## **68 Deering St., BP#2014-02509**

remaining questions:

FIRST FLOOR
68 DEERING ST

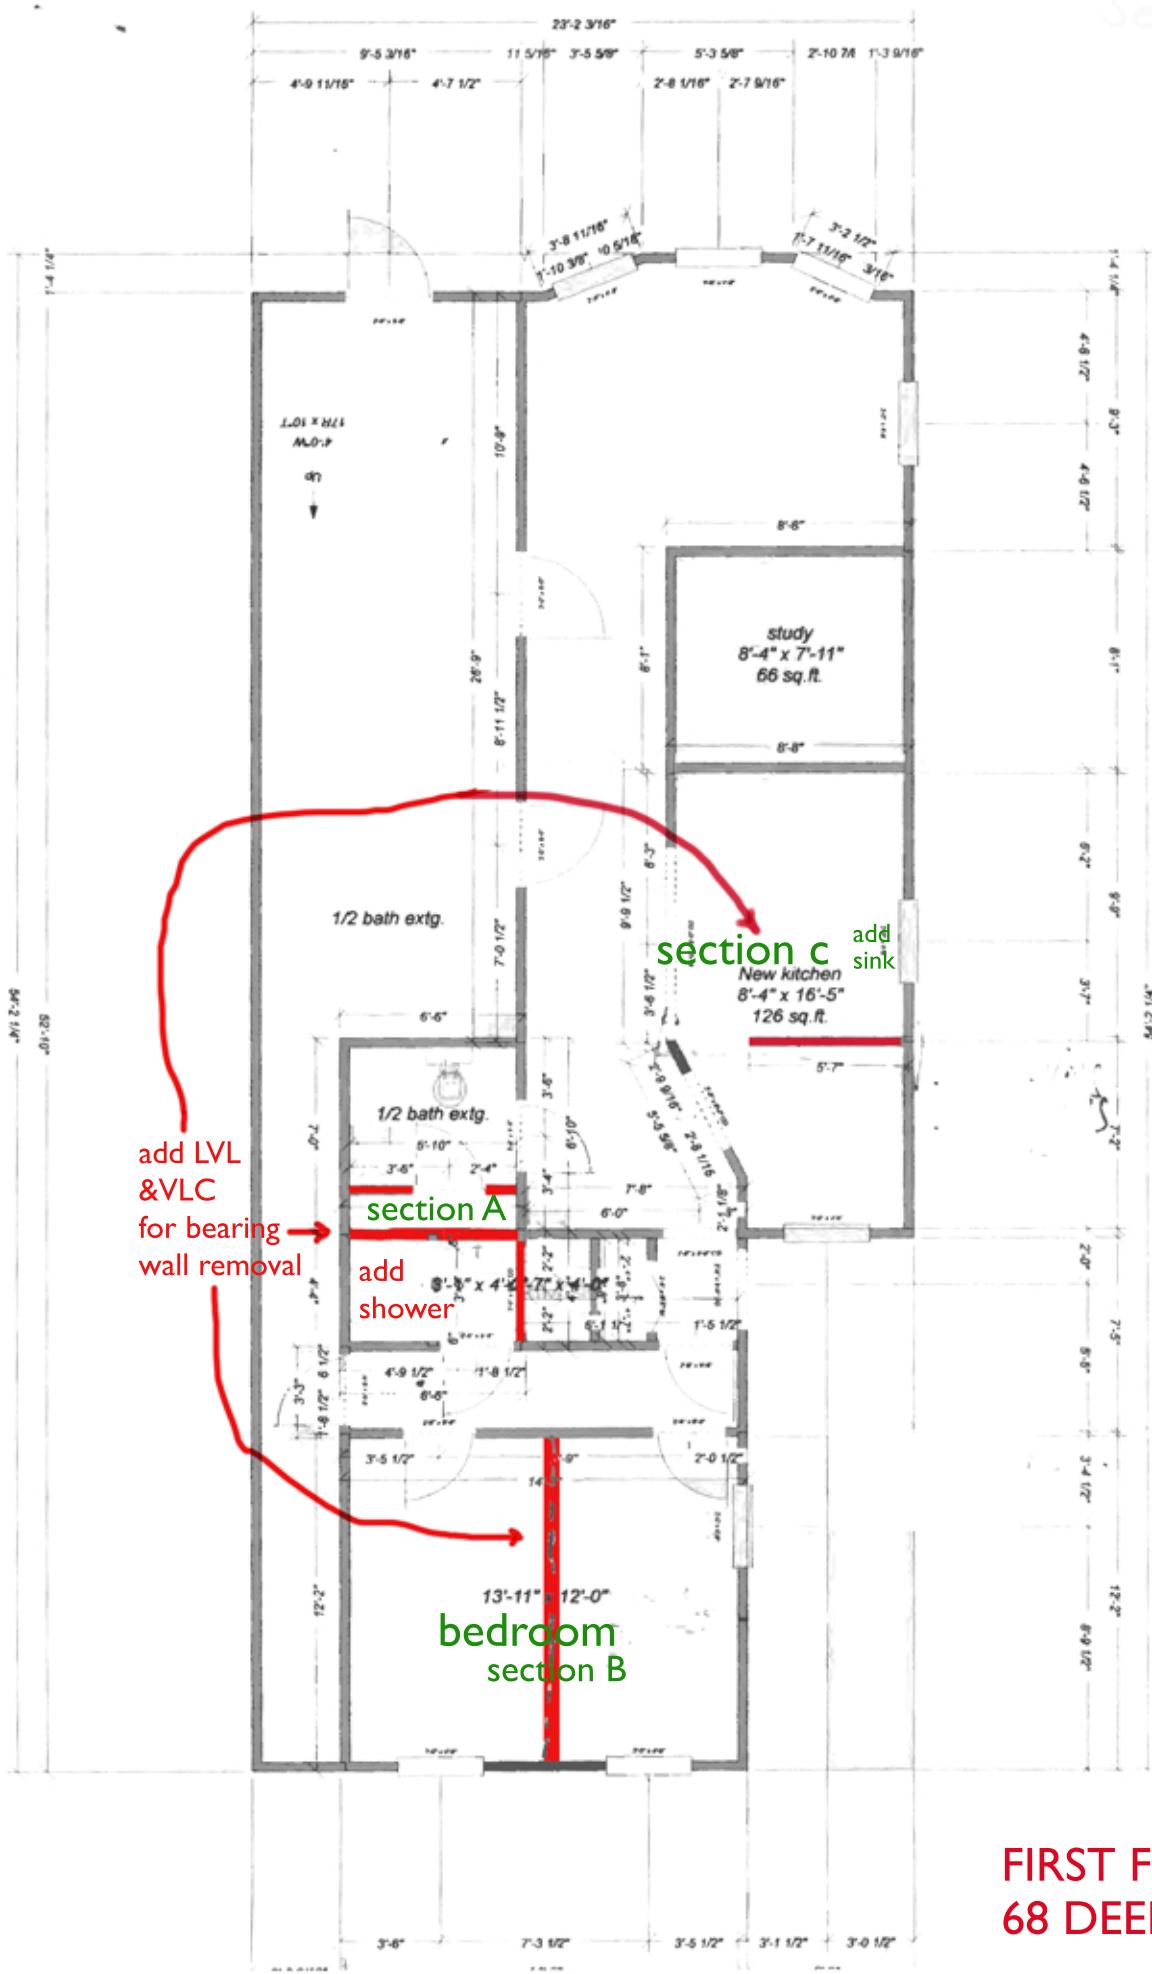
-Diagram of the load bearing path at all new Engineered beams, including any new footings and columns in the basement  
**Steel I-beam for 40" span in bathroom to solid brick wall. I beam carries the upper load with force paths going into the brick supporting the beam. The beam is supported by 6" of brick on either side.**

On the first floor, **only the wall in the bathroom is weight bearing.**

-Provide the wall infill details, ie. a section or plan view of materials  
**Infill is paper faced 2x6" r=19 pink fiberglass. The paper face will be stapled to the framing lumber.**
